HIGH PLAINS FILING NO. 1

PRELIMINARY PLAN

Markup Summary

## PRELIMINARY PLAN

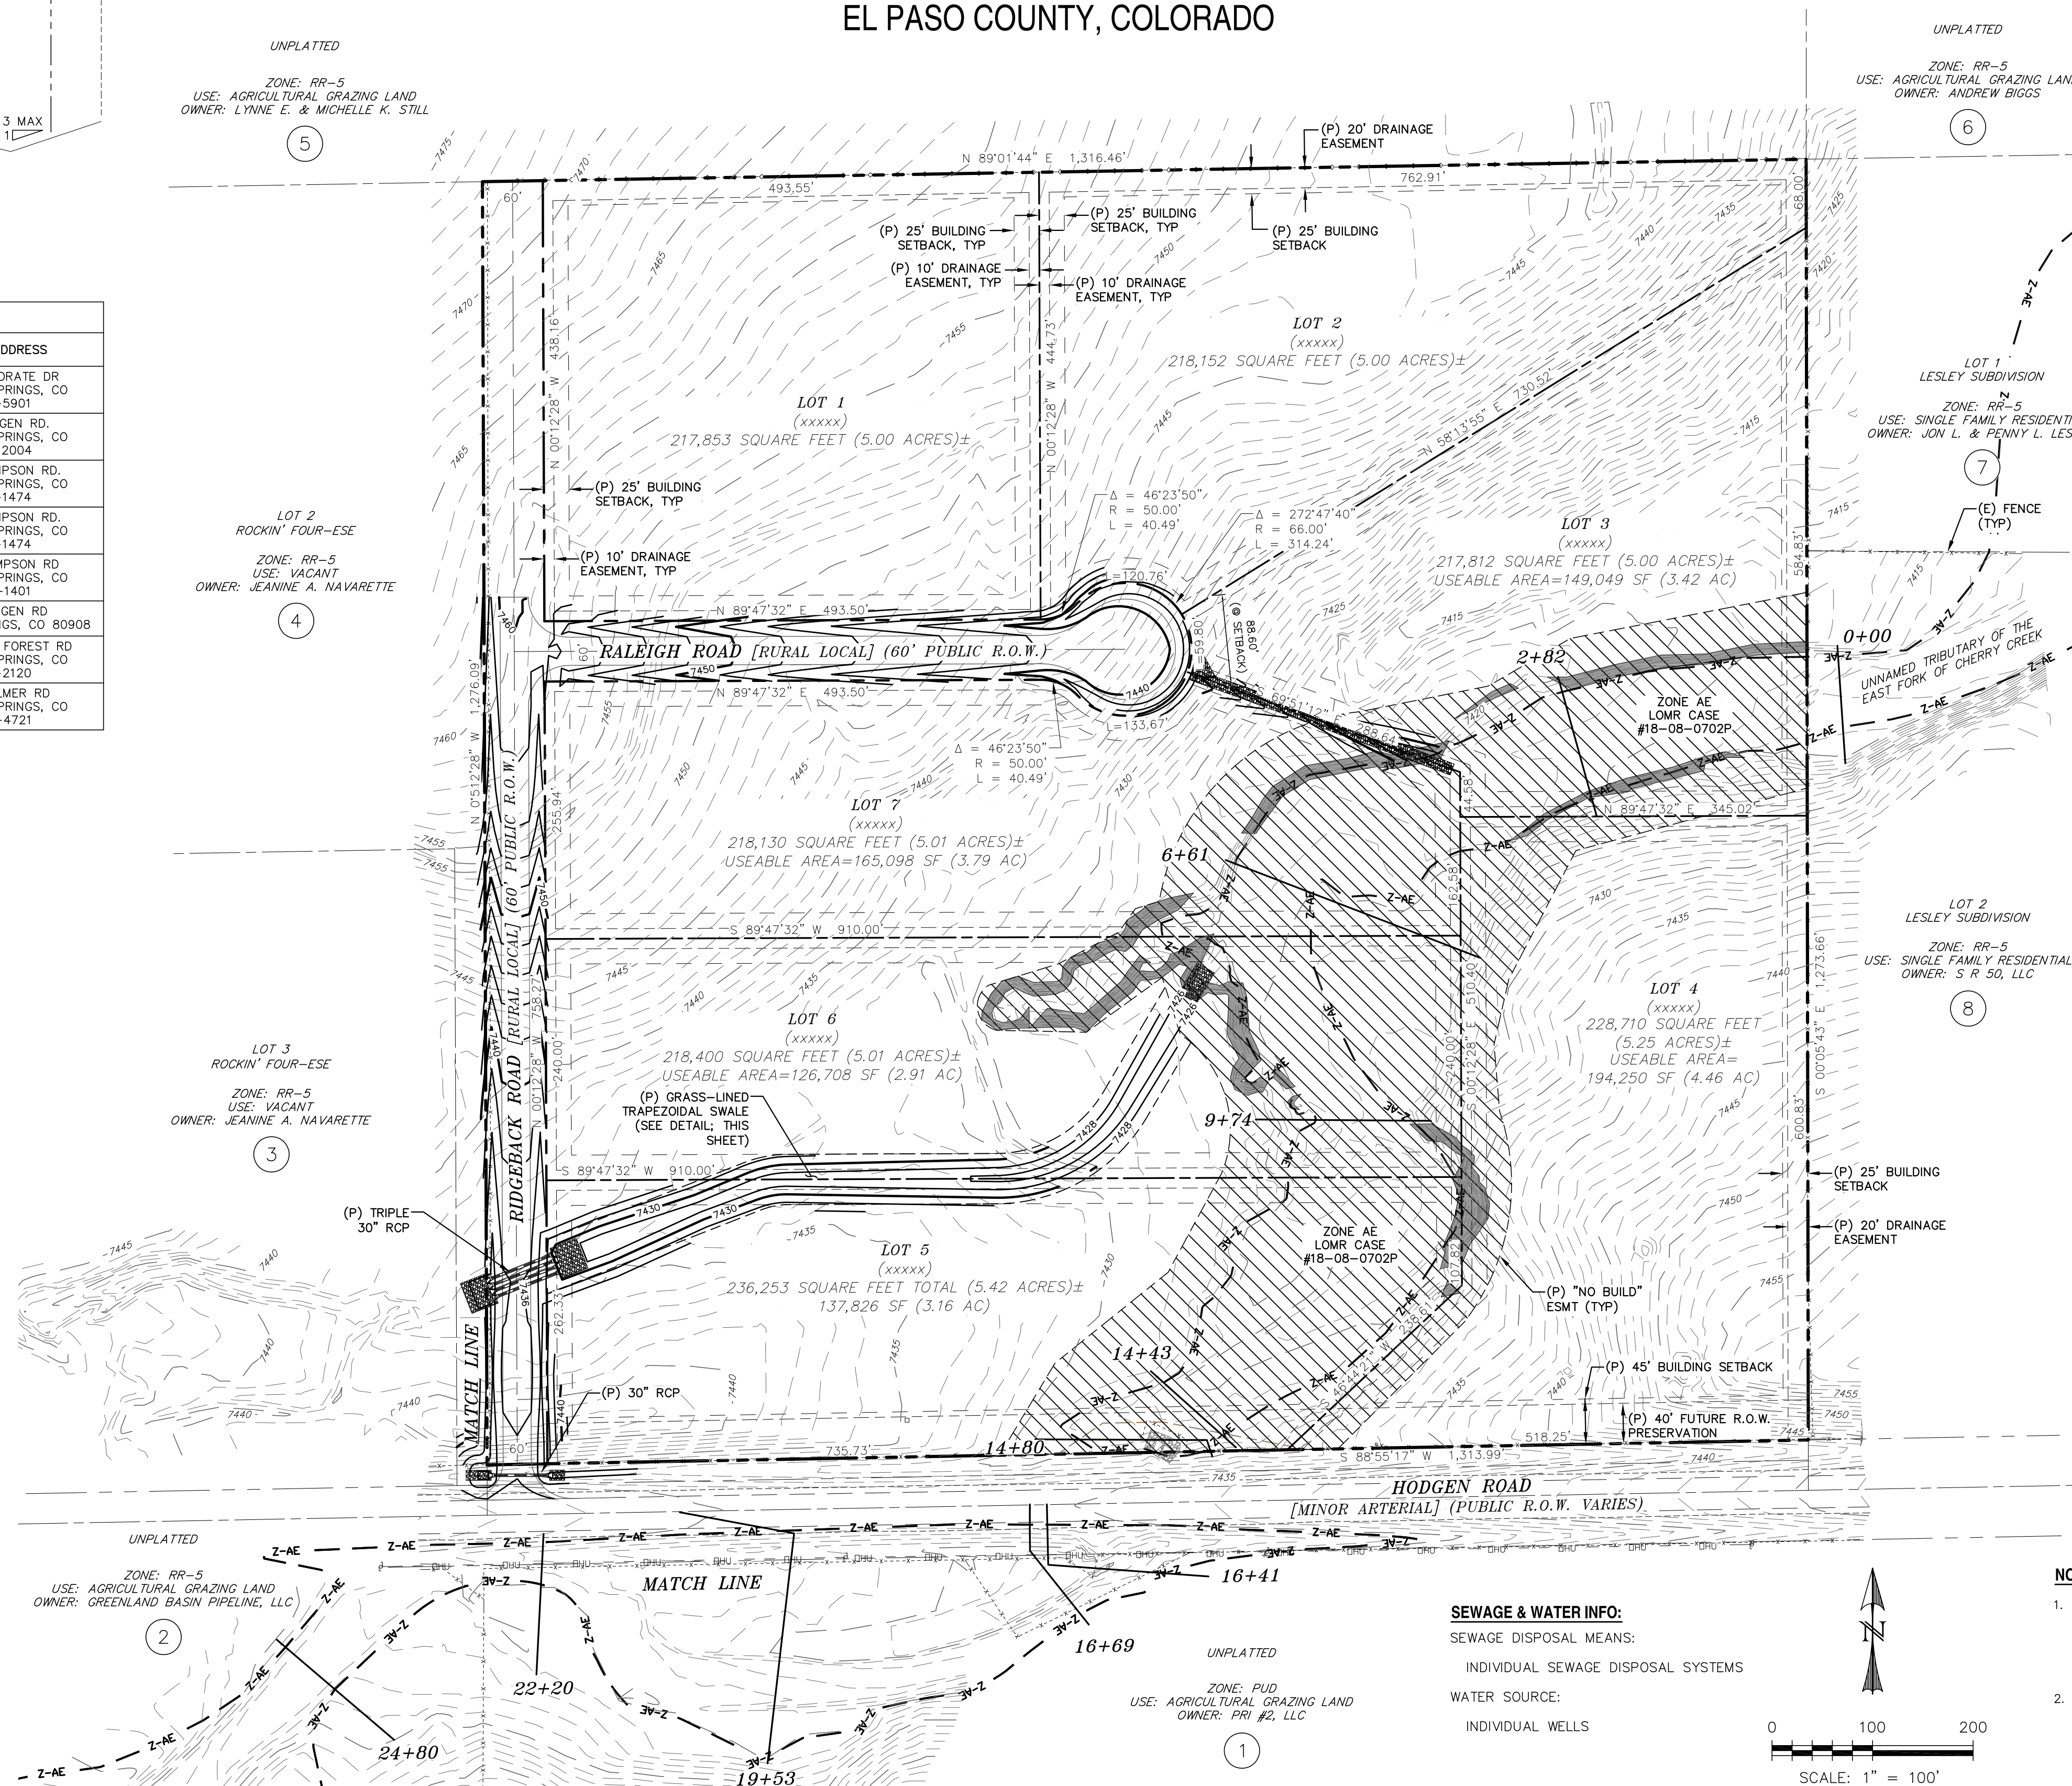
Any area with slope greater than 30% should be no build. Revise net acreage once no-build is shown (including floodplain).

The soils report identifies some potential hazards that can be mitigated. Please either show these areas as no build or add a note indicating the mitigation method.

Please indicate how gas, electric, fire, water and sanitation will be provided.

Indicate road classification and surface material

Indicate road classification and clearly show ROW dedication.

Provide a typical road section for proposed roads

Clearly label FEMA 100yr floodplain and indicate that it is a no-build/no-storage area and/or add to legend

Label whether these are existing or proposed culverts

Move the street label so it's not blocking the street line work which shows the limits of the proposed road.

Provide a preservation easement. Per the MTCP Corridor Preservation Plan, Hodgen is identified as a 4-lane arterial (180' ROW)

Provide a preliminary grading plan

add setback line for when lot width is met.

add bearing
